141070

Brookfield Multiplex
135 King Street
Sydney NSW 2000

Heritage Building South Eastern Zone

Wall Stability Works Associated with Recently Uncovered Site Conditions

01 PROPOSED SECTION A-A
OLD 'SCOTTISH HOSPITAL' BUILDING
1:100@A1

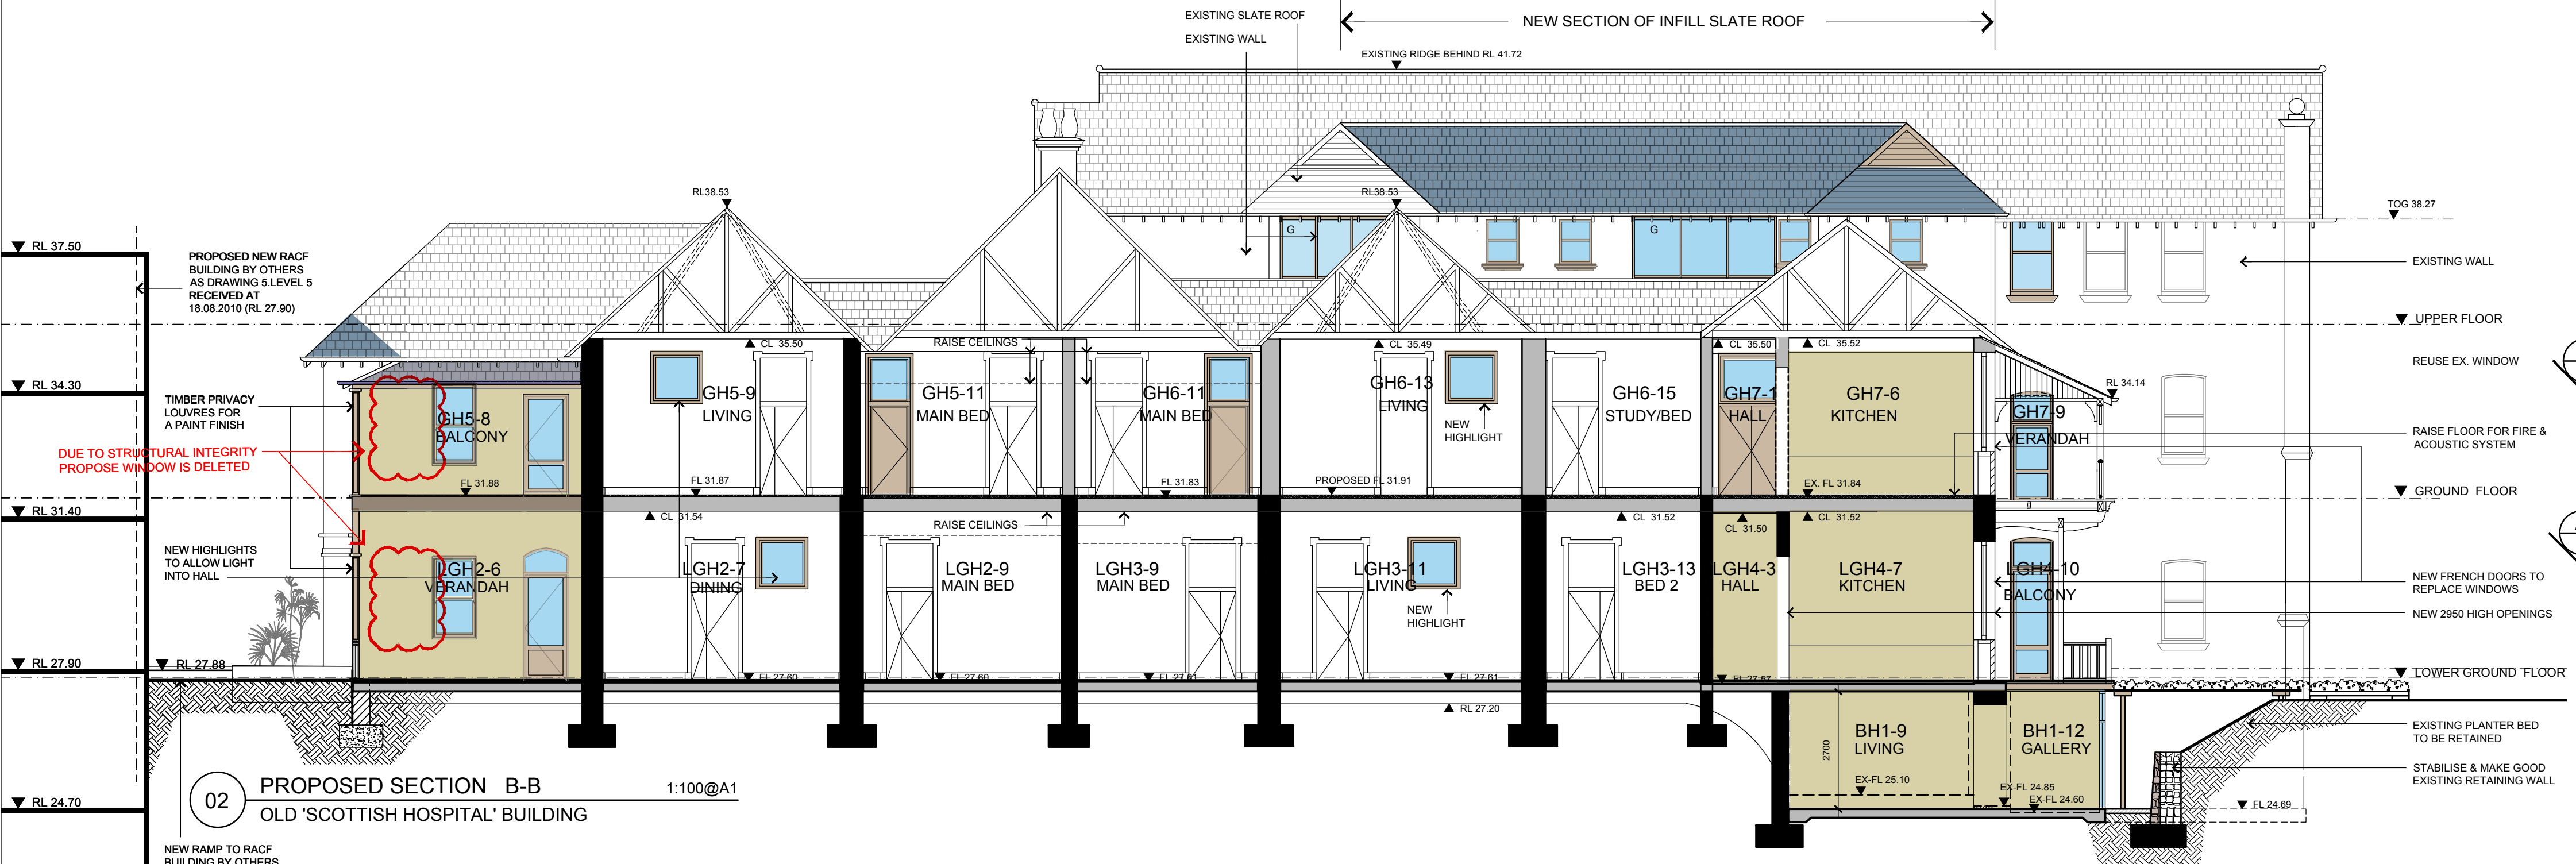
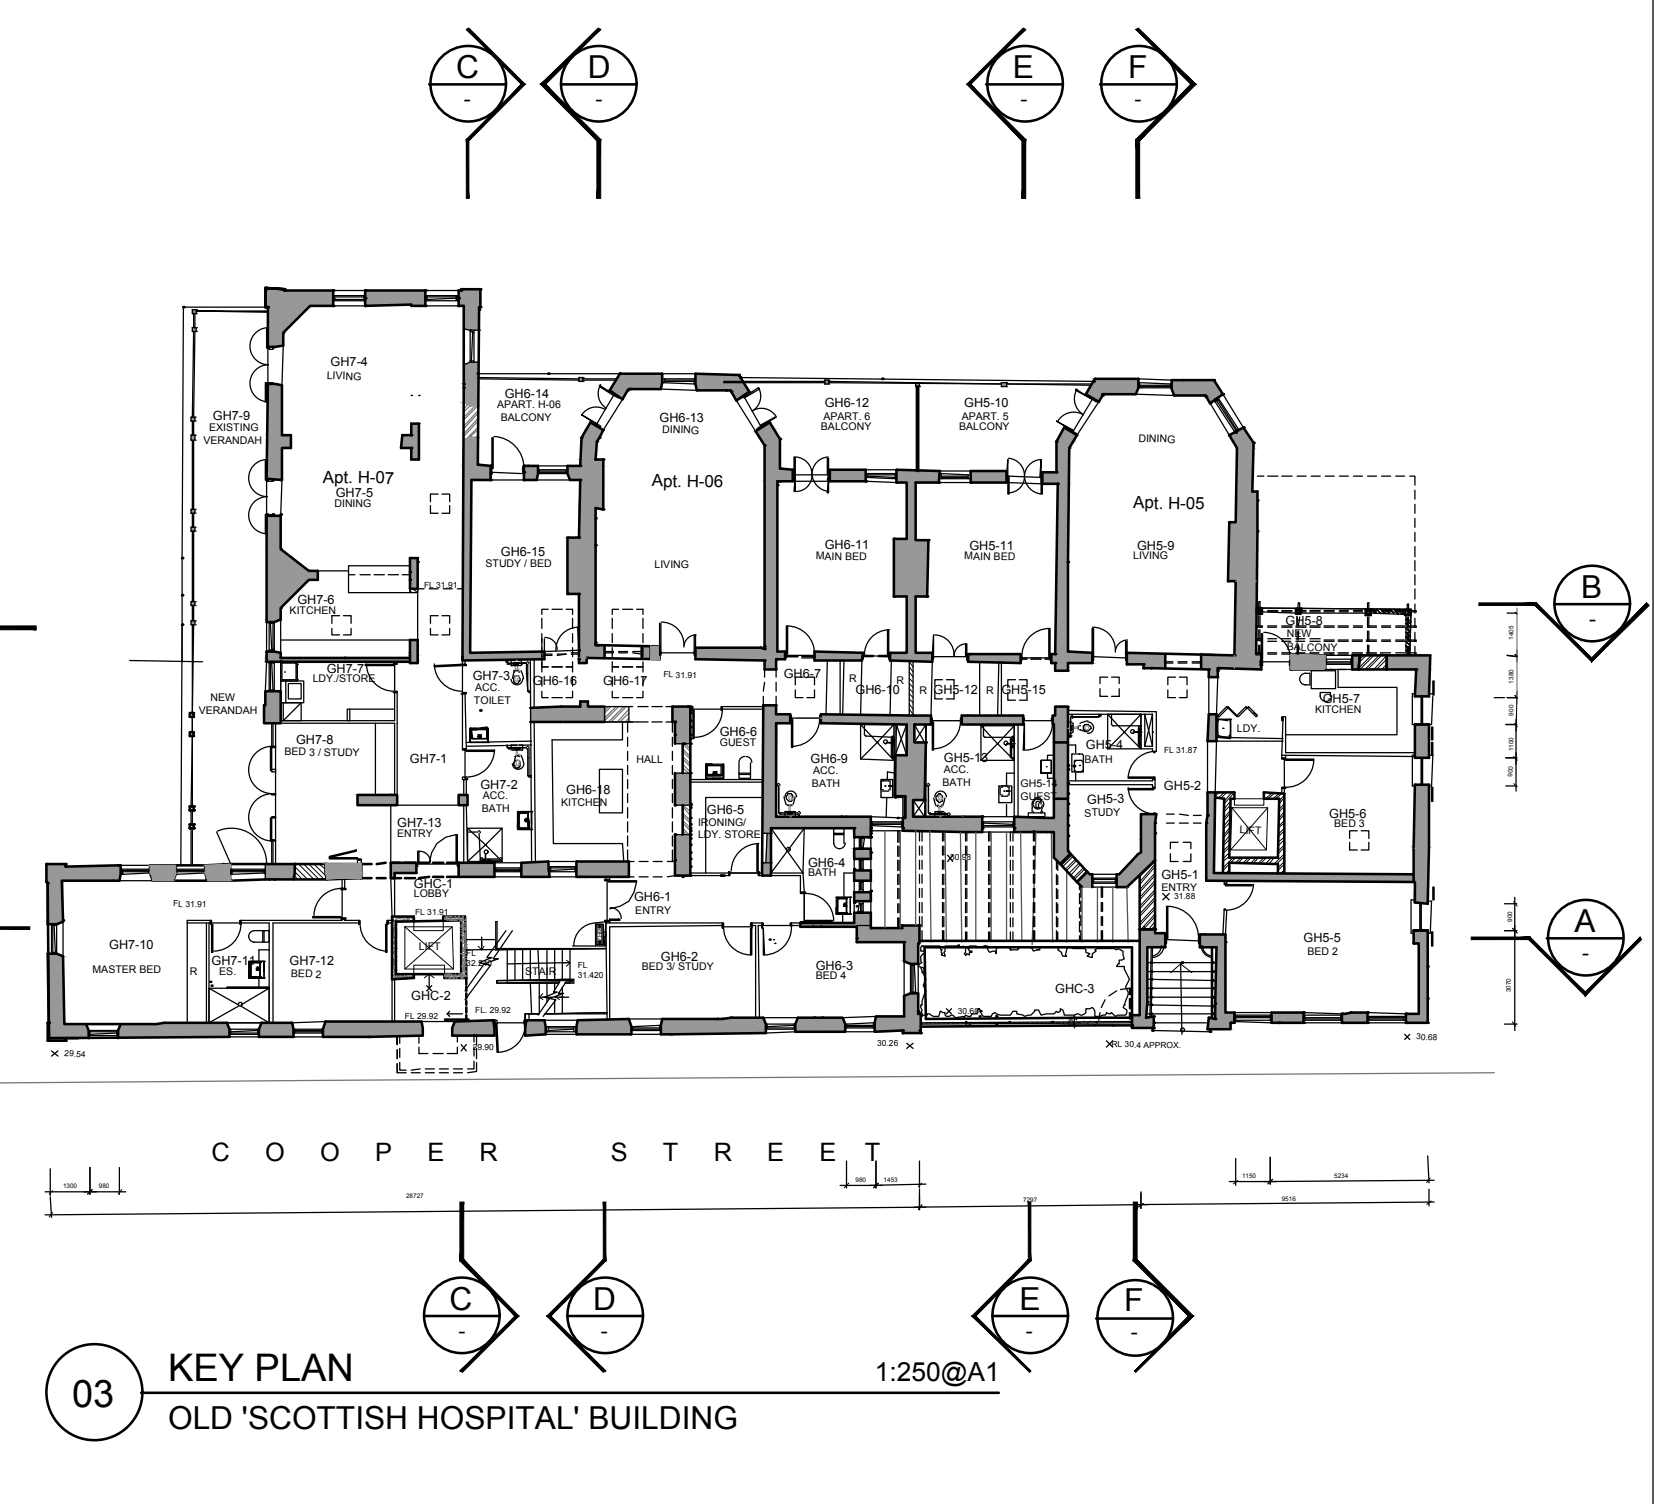
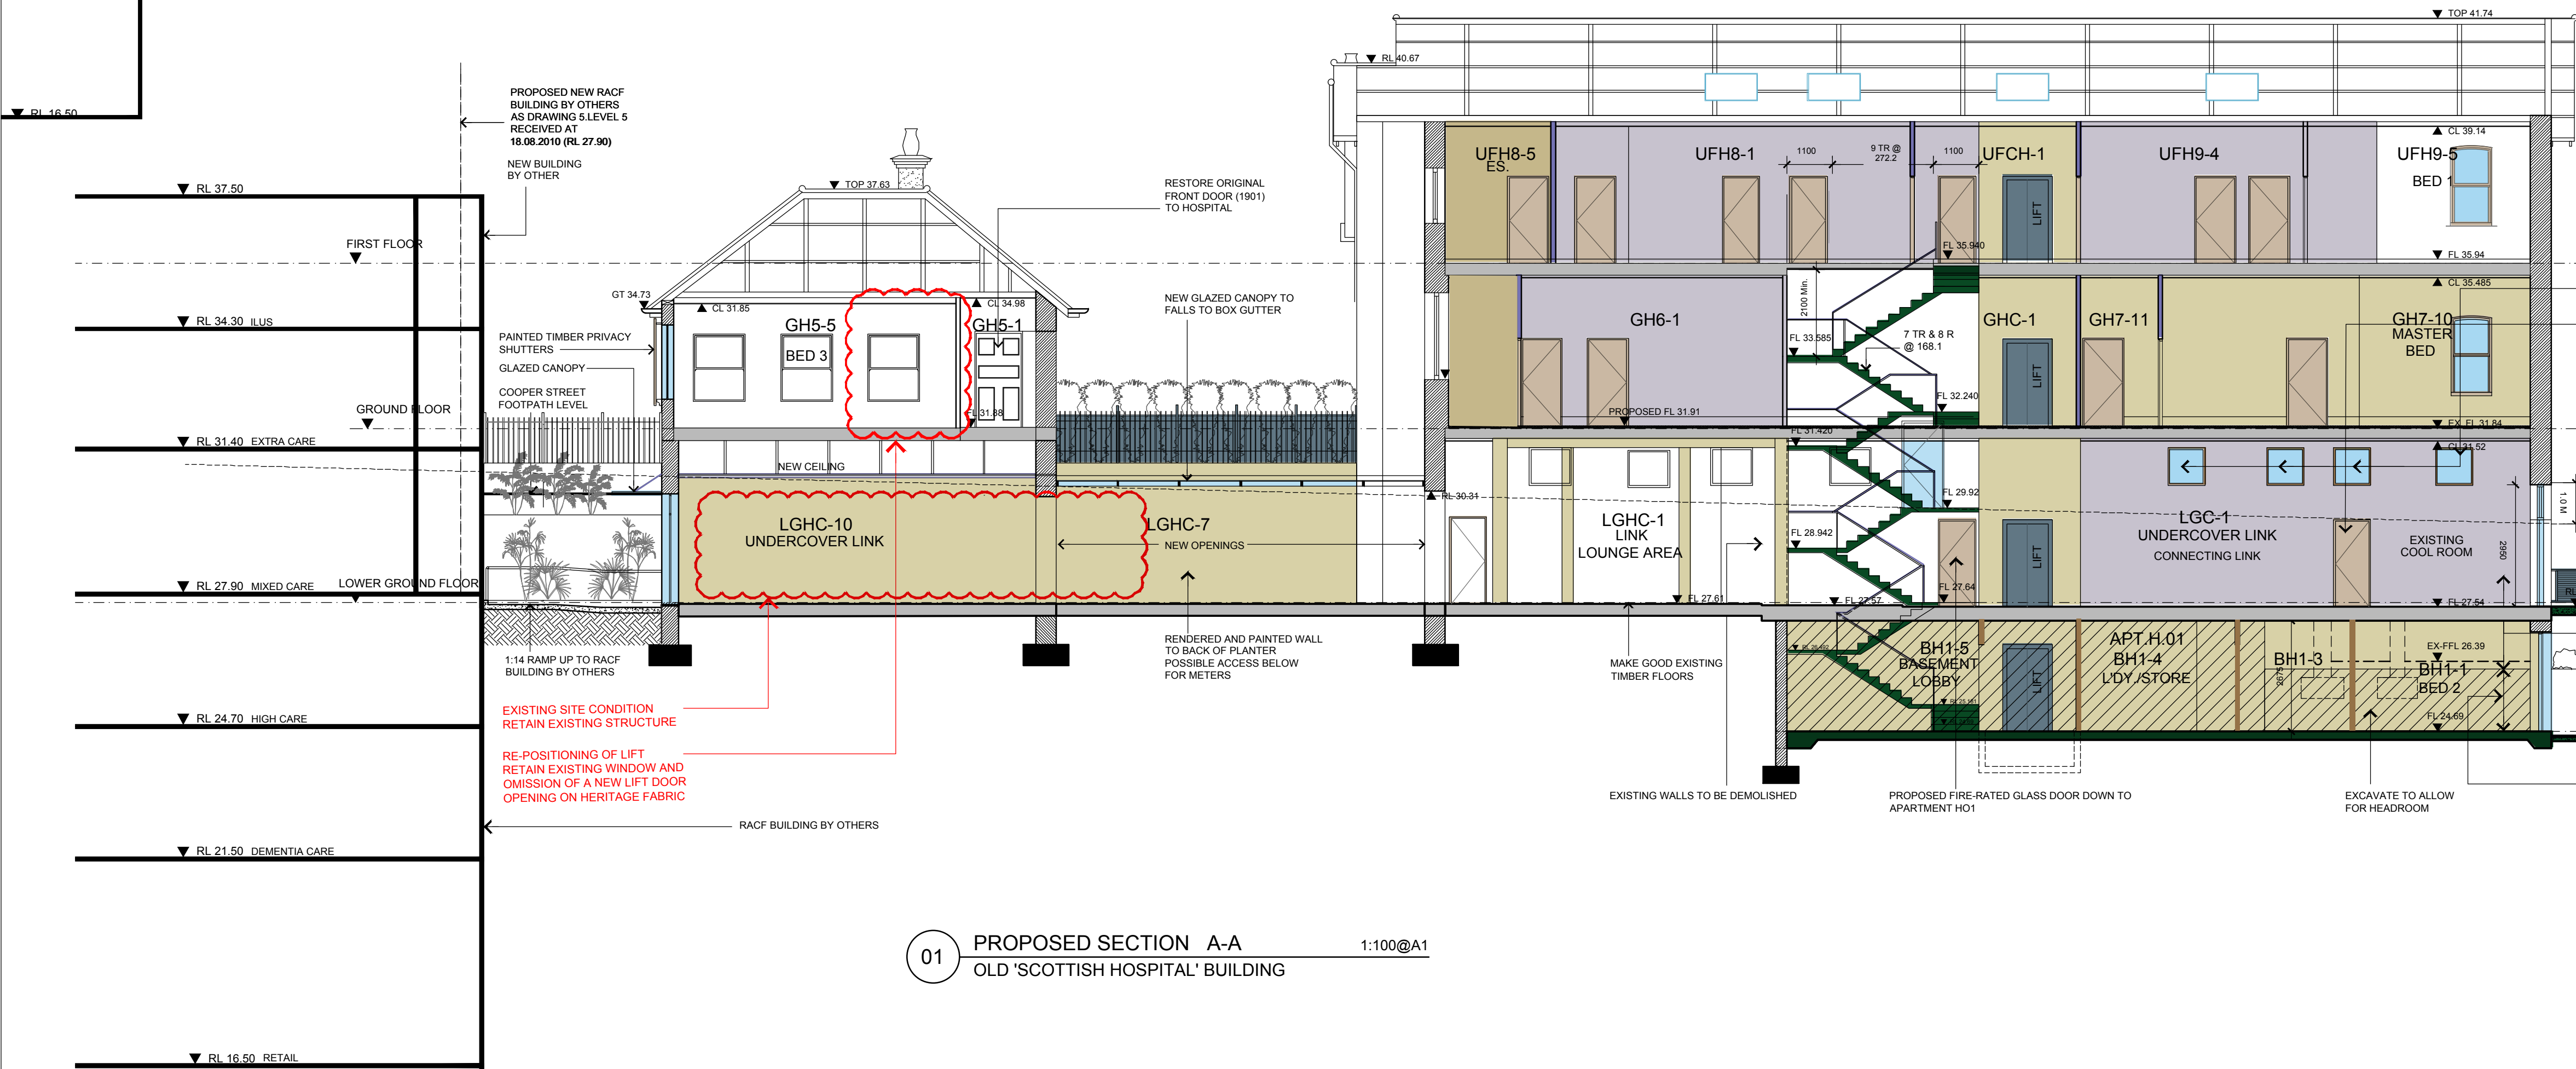
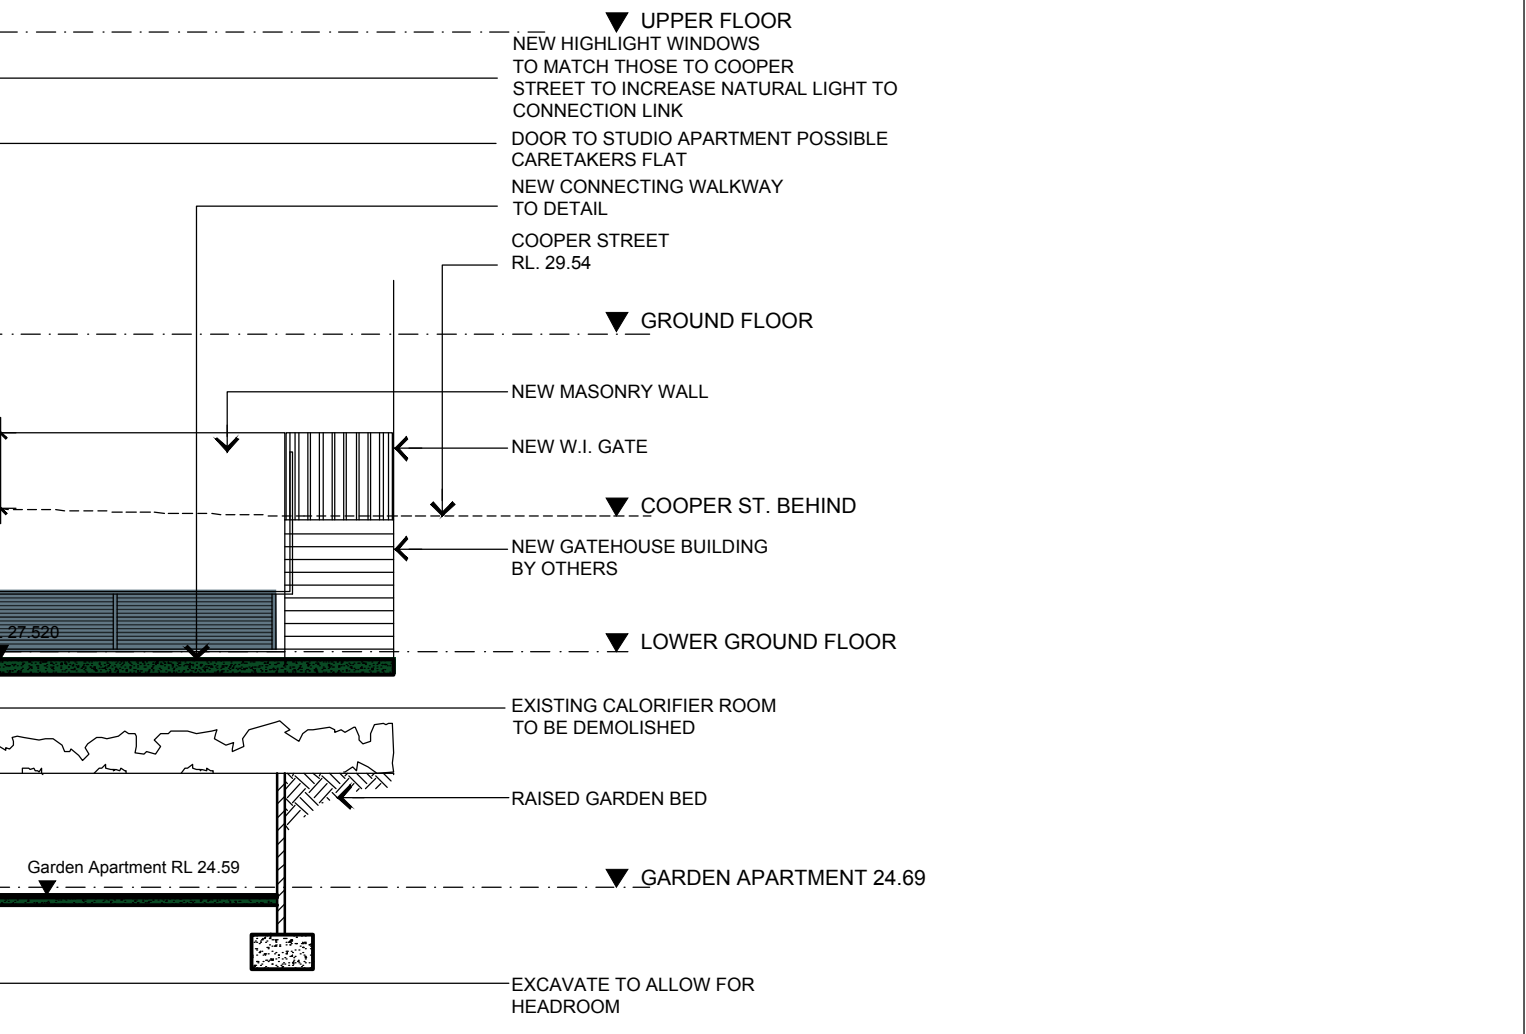
Recent site investigations have confirmed the existing masonry walls as per the attached markup are founded at levels substantially higher than level 5. Some walls were found to have no footing and be sitting directly on the loose sands.

Due to the walls being founded at levels higher than expected, the current approved architectural design levels for the finished floor adjacent these walls would undermine the existing foundations. Therefore underpinning is required to ensure the structural integrity of the existing walls are maintained.
